# CITY OF ALBUQUERQUE

**Re: Caliber's, Washington and Cutler. Grading and Drainage Plan  
Engineer's Stamp dated 11-2-11 (H17/D089)**

LEGAL DESCRIPTION:

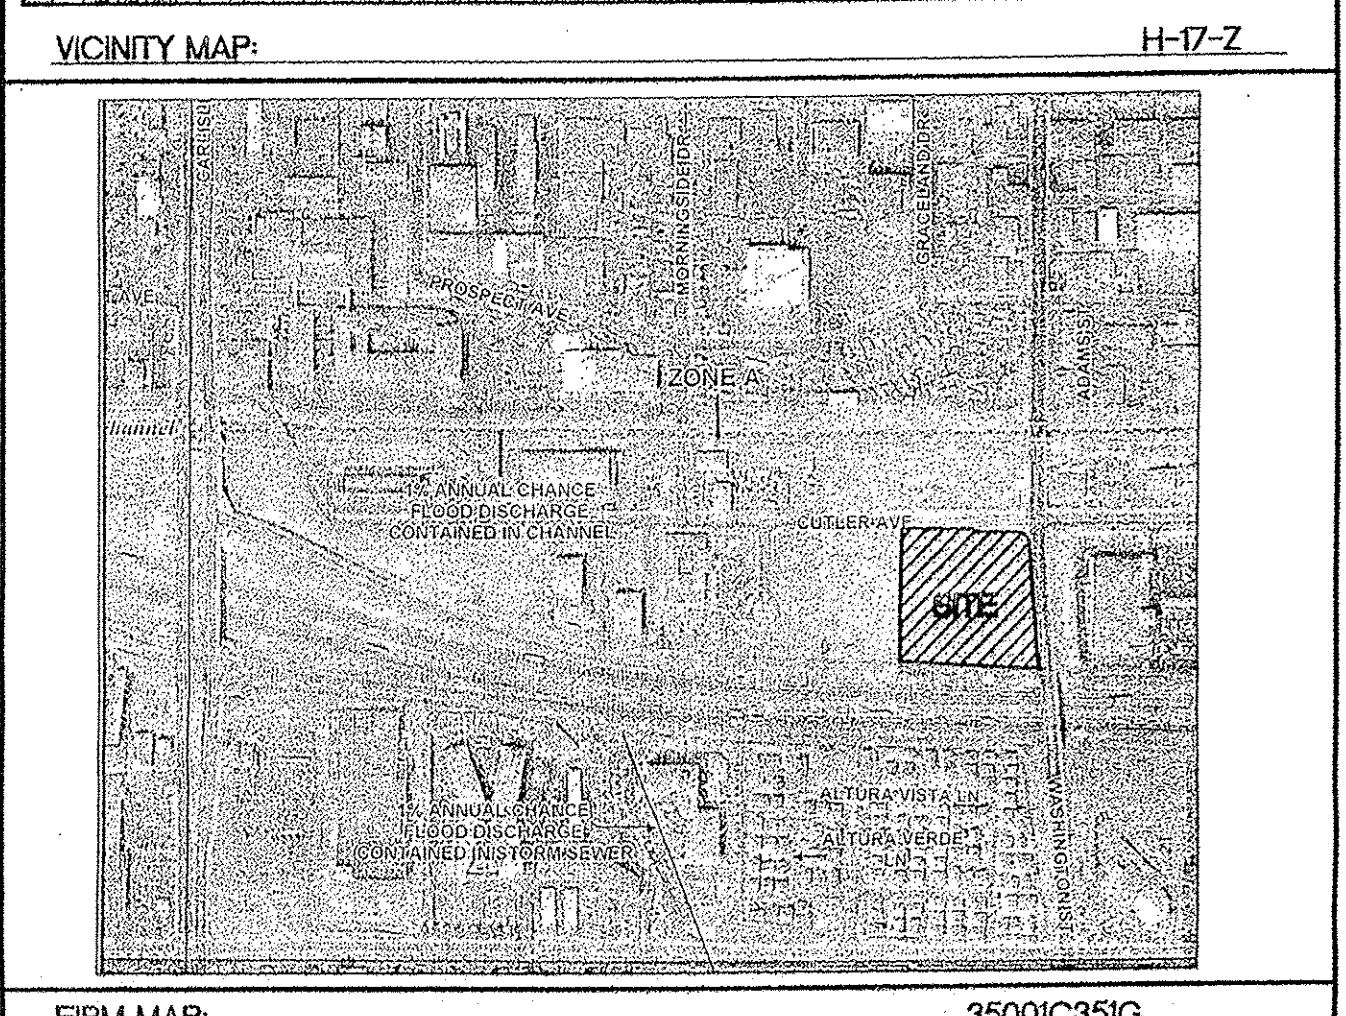
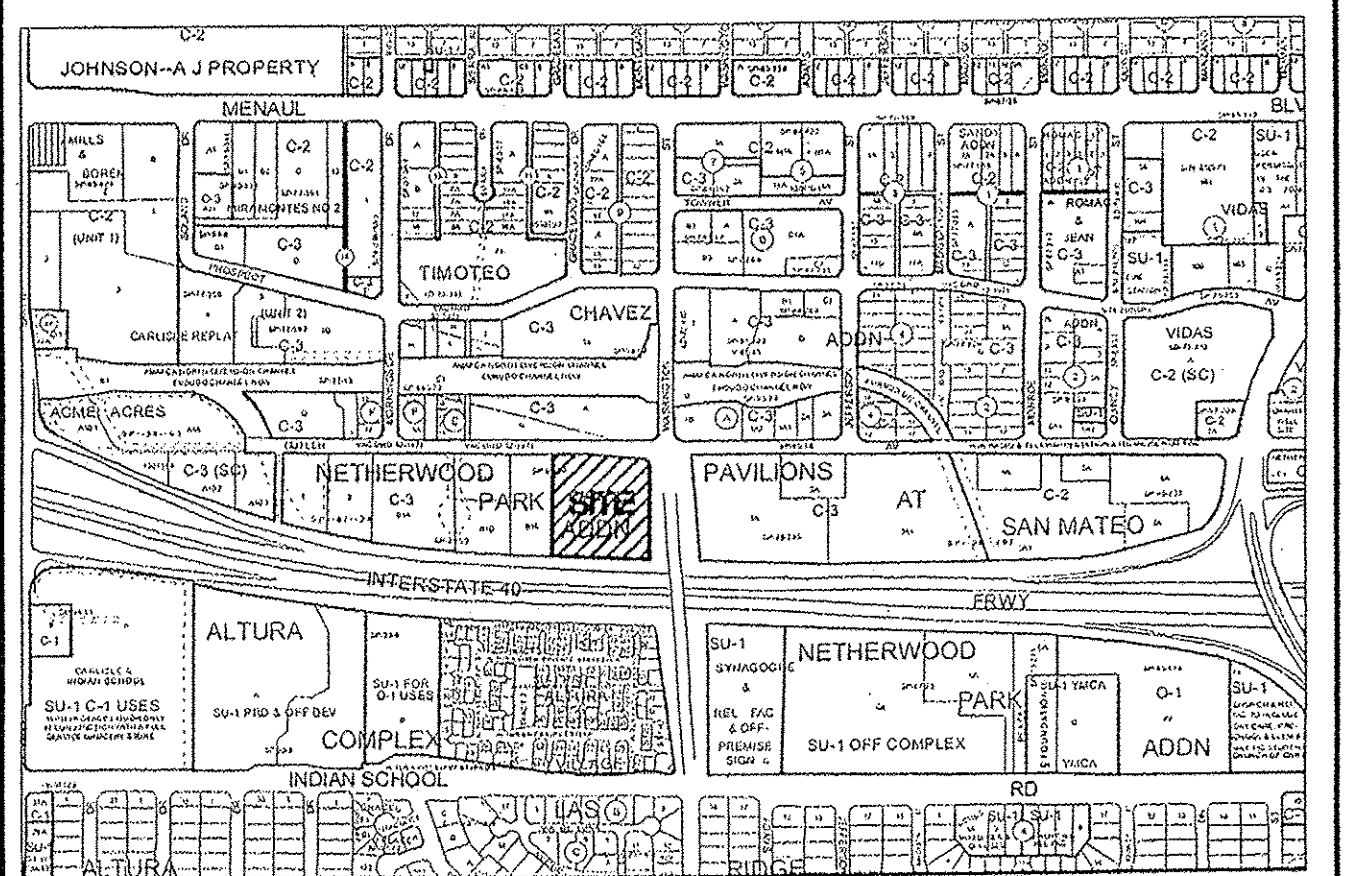
- Per site visit 11-18-11, existing grades at the site appear different than shown on the plan. Provide the date of the survey, the surveyor's name and existing spot elevations.

- Label the existing contours.
- The site has a "bowl" in the middle that ponds a large portion of existing flow, contrary to the statement in the "Existing Drainage" narrative.

- Show the garden wall south of the "Drain to Exist Channel".
- Provide grades along the west boundary to aid in the determination of the slope and swale.

- Sections A-A, B-B, and C-C are translated horizontally.
- Please confirm the size of the "Exist 2' Drainage Outlet". It appears to be 18" wide.
- Provide depths and side slopes of swales in Section B-B and C-C.

- Provide the allowable flow to the site to the west from that site's grading and drainage plan.
- It is not evident that Basin 4 will discharge to the parking lot. Provide details for the swale.

- Provide steepness of proposed slopes on the north side of the property.
- Provide flow line elevations in Cutler Ave near the drive entrance.
- Additional comments may be produced once existing grade data is provided.
